PALERANG COUNCIL

7 February 2011

Capital II Wind Farm Proposal (MP10_0135) - Submission

Figure 2. Development envelope and site plan, showing nearby houses in blue, existing or approved wind turbines in red, proposed turbine envelope within the black outline, and vantage points of the photos contained below.

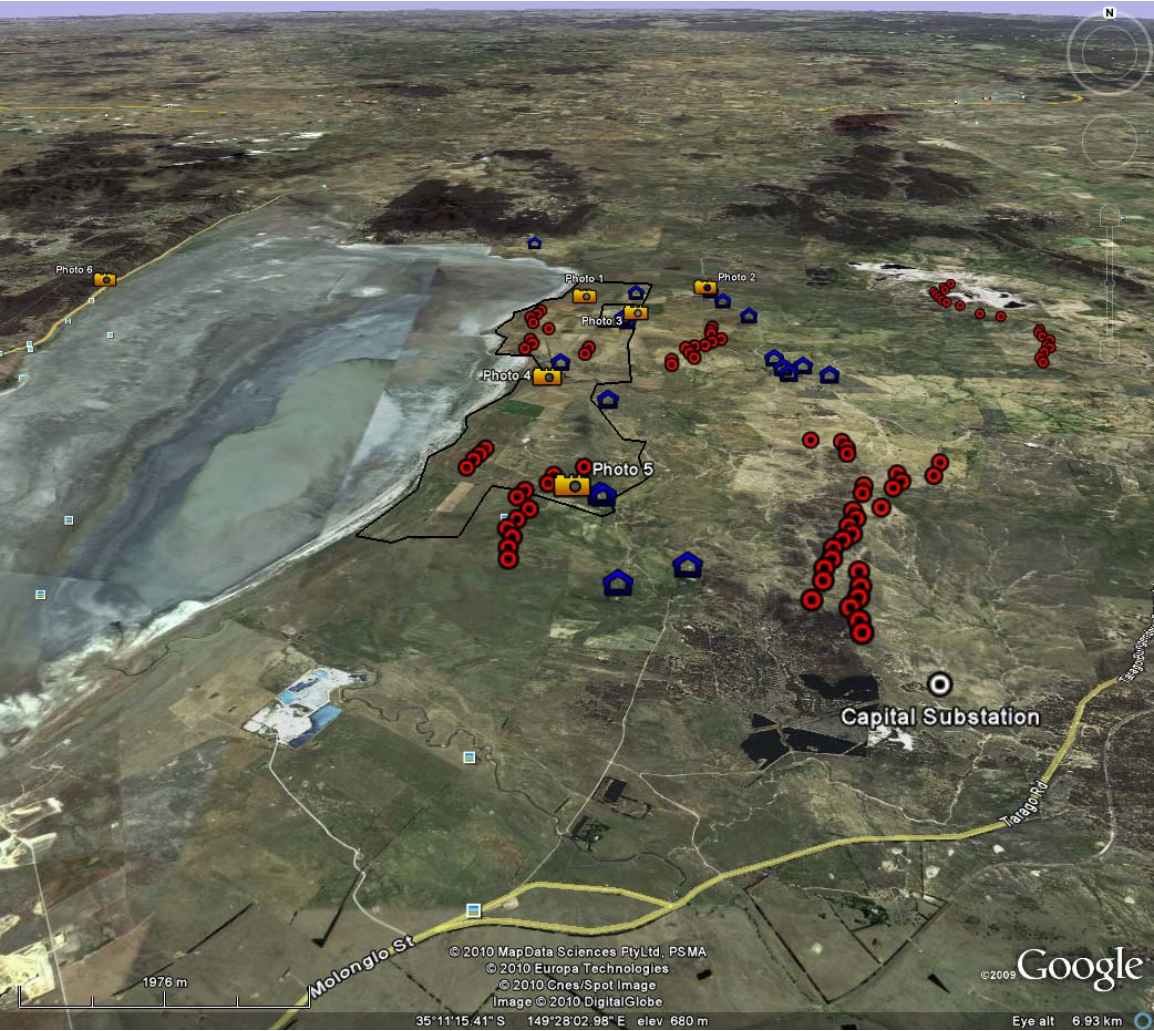
It is requested that the applicant be required to bitumen seal the 400m section between 3.00-3.40 km from Taylors Creek Road where there are 2 houses close to the road. These are shown by blue squares on Fig 26 of the EA. It is further considered that the remaining length of unsealed Western Leg Road should be re-sheeted with high standard gravel that will emit less dust than the current surfacing.

Council requests that conditions of consent be imposed to ensure that Western Leg Road is upgraded to an adequate standard for the traffic associated with the proposal (as per the requested conditions of consent at the end of this letter).
